HORNSEA PROJECT THREE OFFSHORE WIND FARM

Planning Inspectorate Reference: EN10080

**Annex D4: JNCC and Natural England advice on offshore benthic  
ecology**

7 November 2018

Figure 2.1: Seabed sediment and sandwave distribution within the Hornsea Three Offshore Cable Corridor Disposal Site.

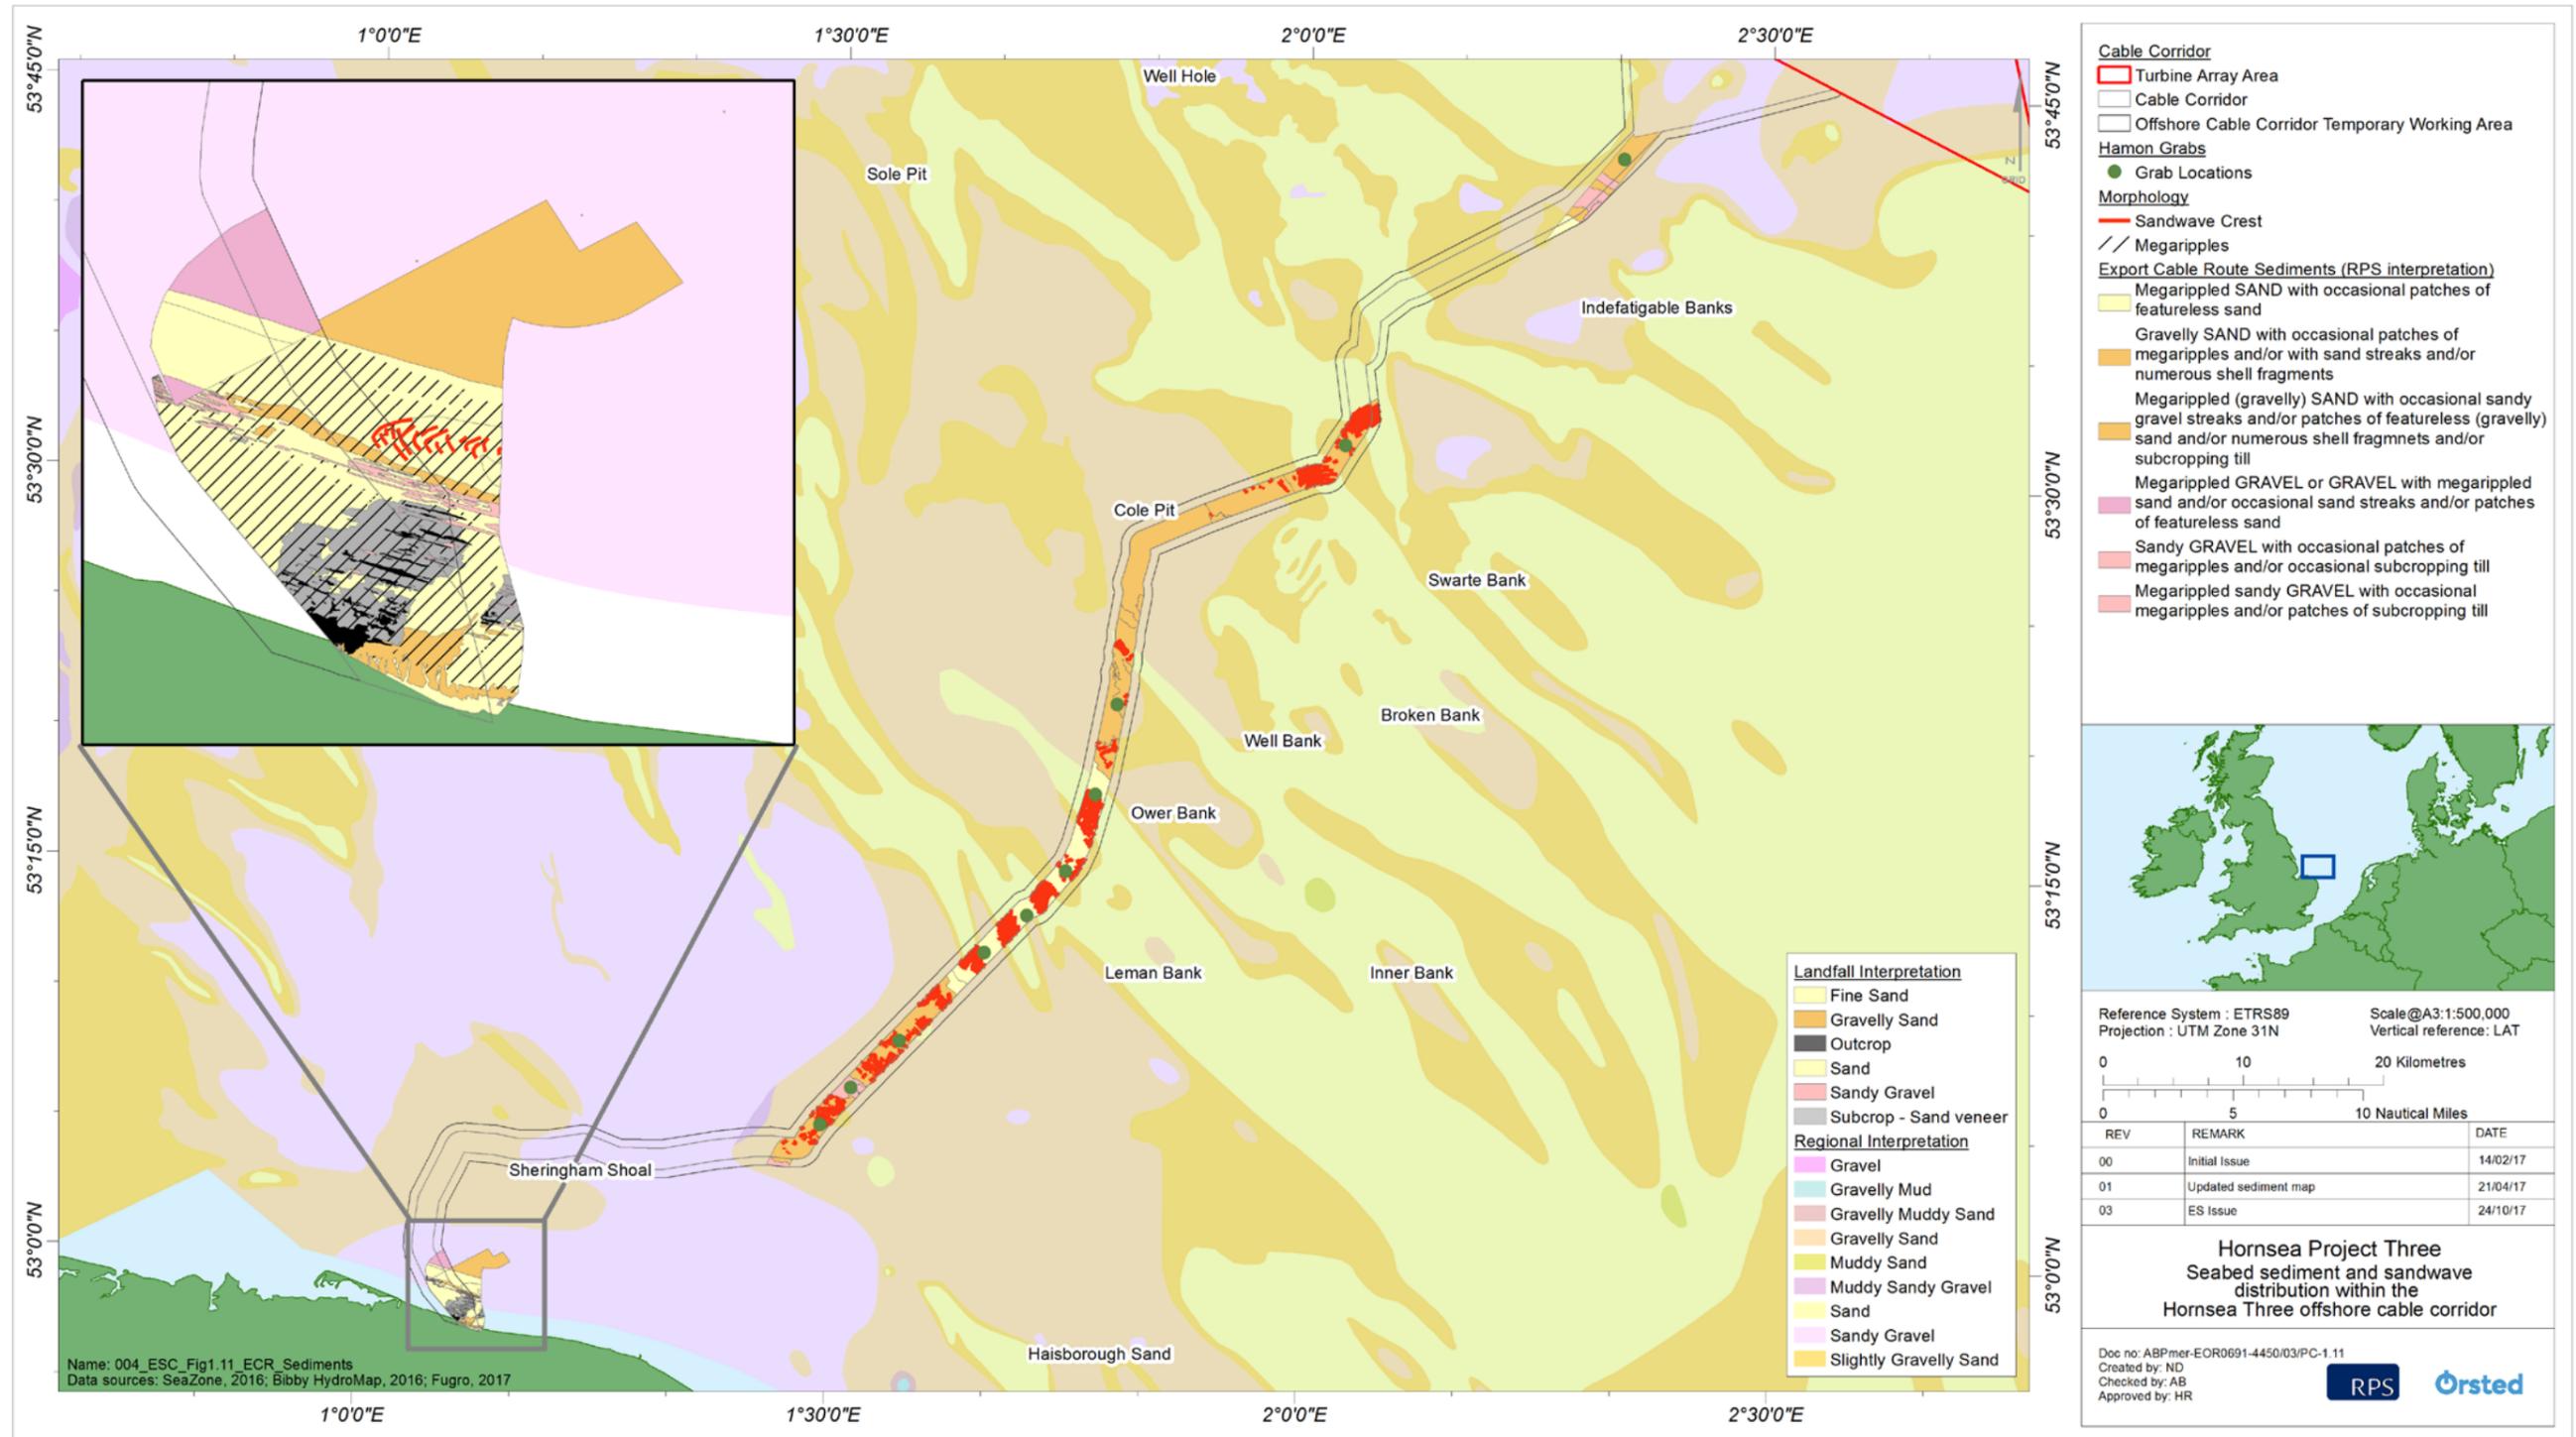
- 3.17. Please refer to the advice provided on the cable protection and sandwave levelling clarification notes in Annexes D2 and D3.
- 3.18. We do not believe that the following matters have been addressed:
- The extent to which the sandwave heights include the heights of megaripples on top of them is unclear. It would be helpful to understand how much height megaripples could add.
  - It would be helpful to understand if there are results from Race Bank to demonstrate recovery of sandwaves from trenches at 6m depth.
  - It is unclear how The Applicant has considered the change in mobility across the site and whether the majority of the sandwave clearance will focus around

Ower and Leman Banks. It is unclear if the methods need to be different across the site.

- The Applicant should provide further detail as to how they are anticipating that cables will stay buried in a mobile regime where changes in seabed can be in the order of several metres per year and whether these areas of increased fluctuations in seabed correspond to areas of deeper sandwaves.
- The Applicant should provide further justification around the applicability of sandwave clearance modelling for Hornsea Project Two given that the sand mobility within the Hornsea Project Three development site are considerably different.
